Rocglen Coal Mine Extension Project

Response to Submissions

June 2011

**Rocglen Coal Mine Extension Project
Project Approval 10_0015
Response to Submissions**

Figure 1 Site Locality showing Biobank offset areas

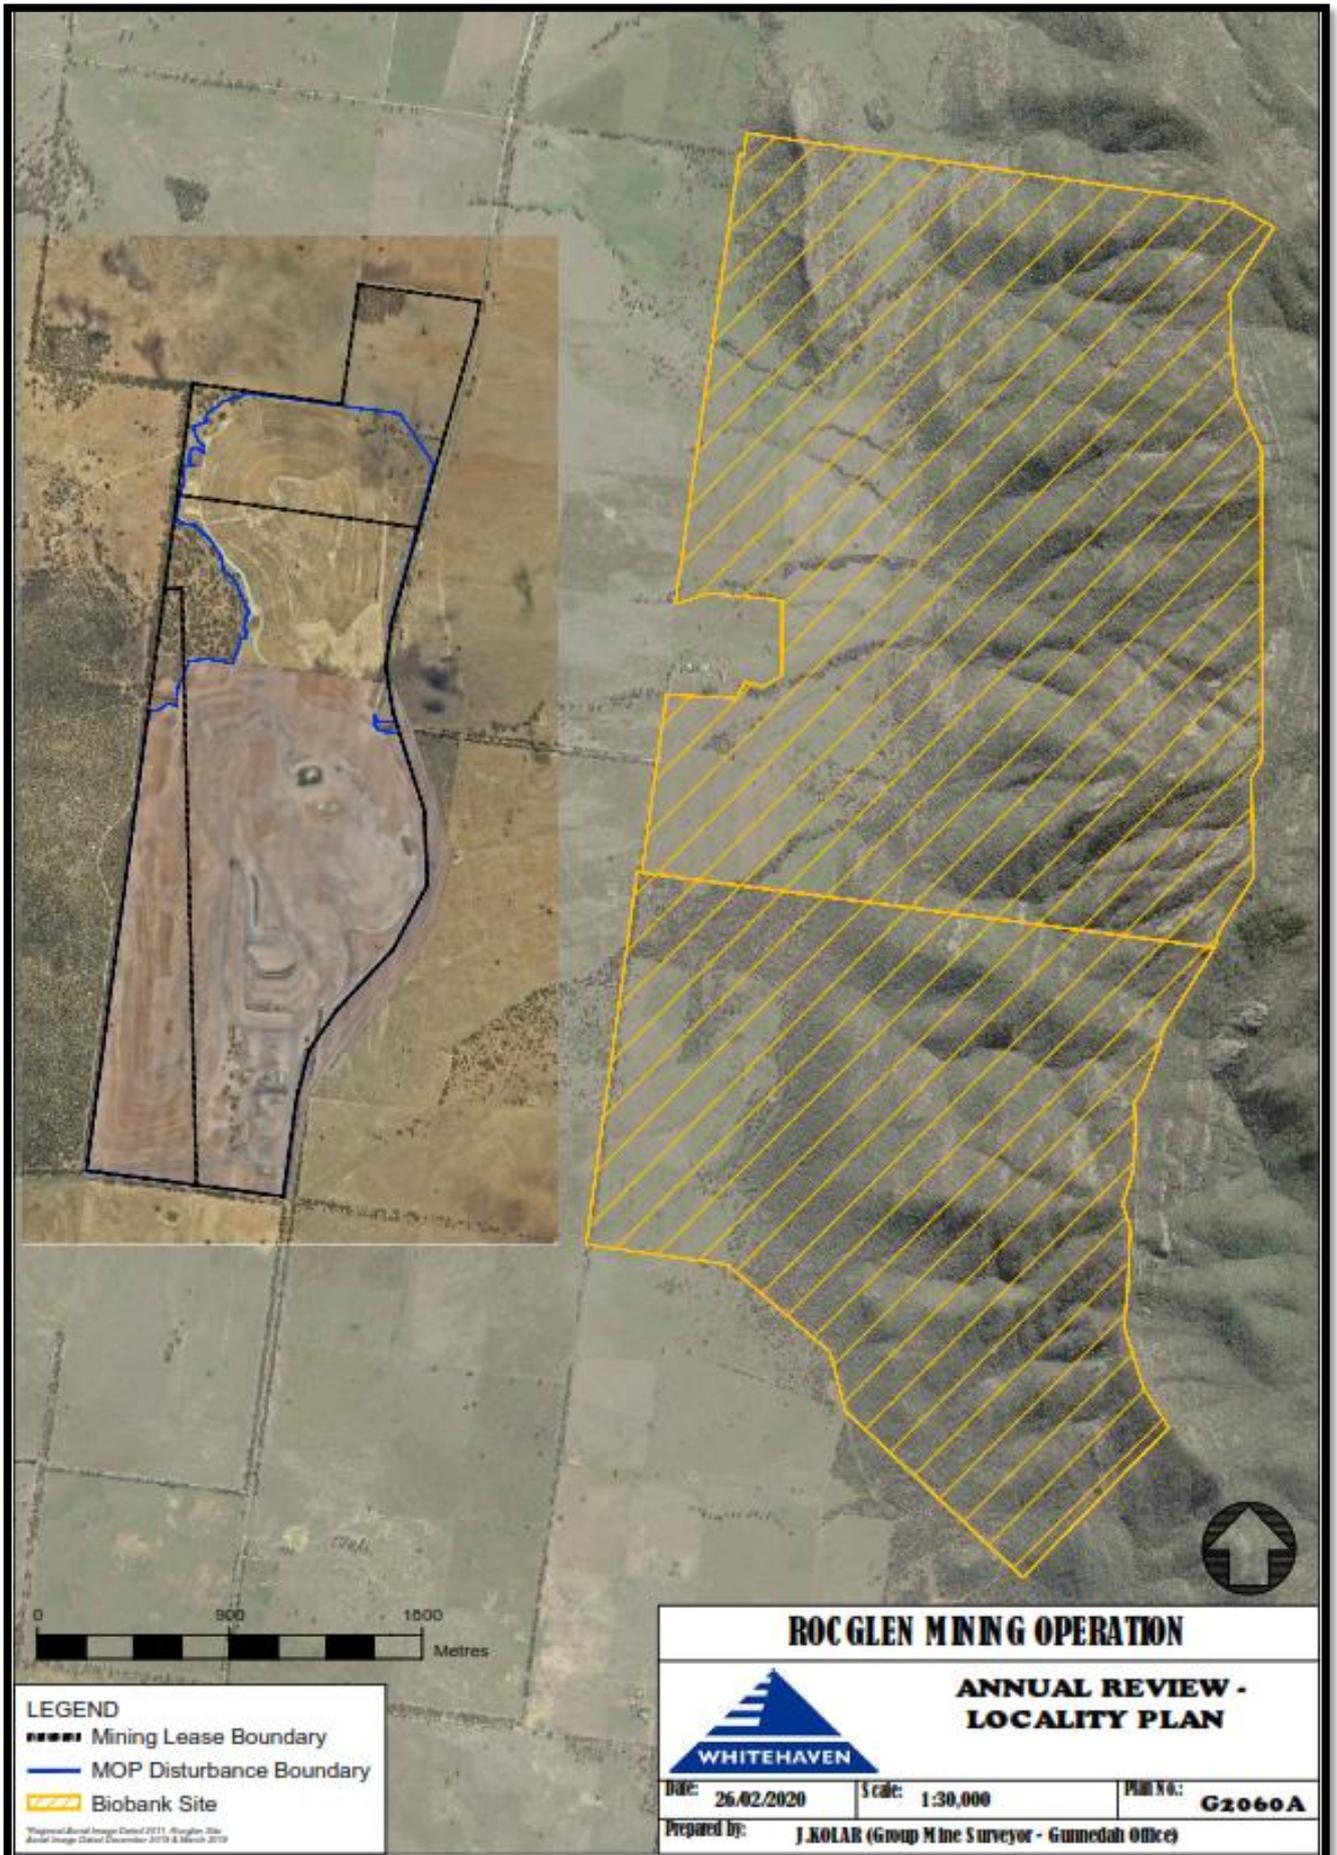
To assist in the assessing the degree of risk of future disturbance to the proposed offsets, please provide details of all identified coal resources (including current or likely exploration or mining applications or leases) in the vicinity of the proposed offset sites.

Whitehaven does not know to any certainty the location and details of all economic coal resources within the area, and can certainly not predict likely exploration or mining applications/leases within the area.

We anticipate that the SEWPaC is trying to ascertain the potential for the proposed offset site to be impacted upon by future mining activities. Given that the *Biodiversity Offset Strategy* (ELA 2010) for the Rocglen Extension Project (including replacement of original offset areas) is to retire the full 4,859 credit requirement from the Whitehaven Regional BioBank Site, there will be no opportunity for the offset site to be diminished or impacted upon.

As outlined above, the Whitehaven Regional Biobank Site will provide for the long-term conservation of approximately 1,500 hectares of Whitehaven-owned land approximately 900 metres to the east of the Project Site. The BioBank Site will be protected on title by a BioBanking Agreement entered into with the NSW Minister for the Environment under the TSC Act and will be managed in perpetuity in accordance with a BioBanking Management Plan approved by the Minister with management funds (calculated for in-perpetuity management) held in Trust (see Section 5 of the *Biodiversity Offset Strategy*, ELA 2010).
